OWNER
 CHEROKEE METRO DISTRICT
 6250 Palmer Park Blvd
 Colorado Springs, CO 80915

MOBILE OFFICES
SITE DEVELOPMENT PLAN

SHEET NO: **DP-01**
 DATE: 12/20/2017
 PAGE NO: 1 OF 1

SHEET NO:
ADA-01
DATE:
02/14/2018
PAGE NO:
1 OF 1

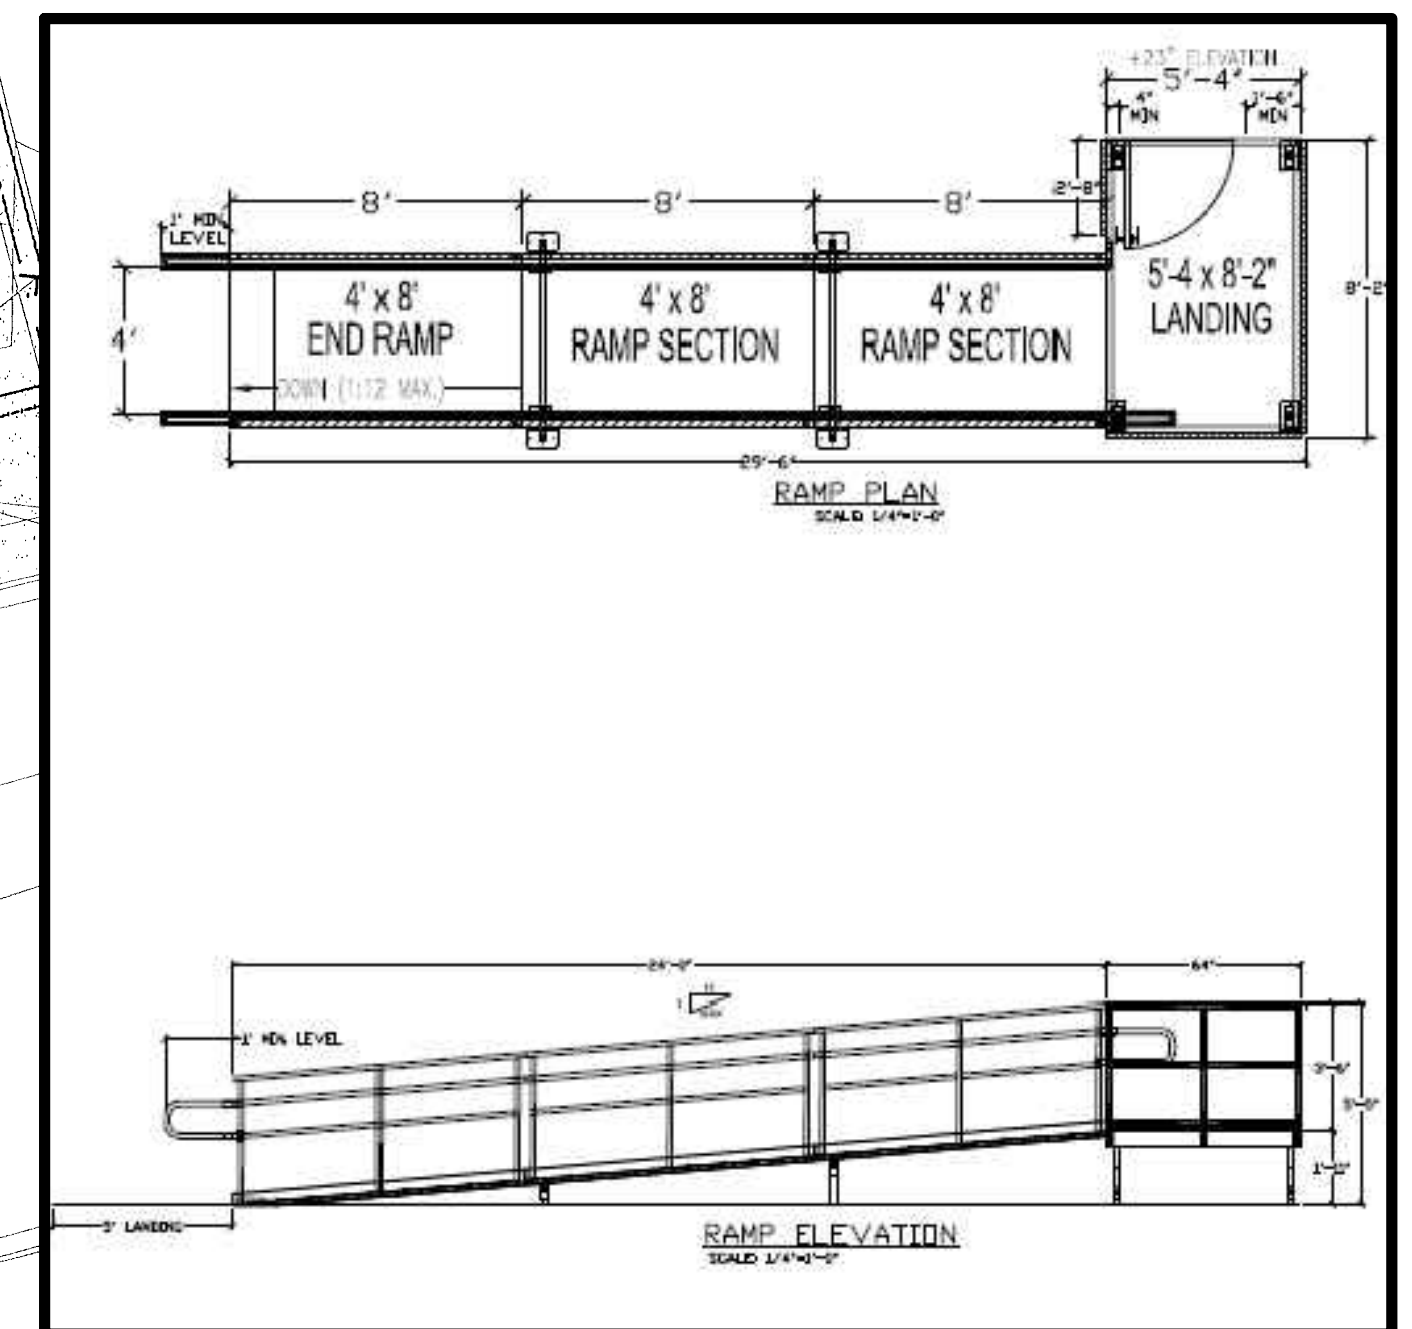
Per new county standards all site development plans must have the following note:
The parties responsible for this plan have familiarized themselves with all current accessibility criteria and specifications and the proposed plan reflects all site elements required by the applicable ADA design standards and guidelines as published by the United States Department of Justice. Approval of this plan by El Paso County does not assure compliance with the ADA or any regulations or guidelines enacted or promulgated under or with respect to such laws." Also a separate sheet showing the ADA access routes needs to be included with site development plan.
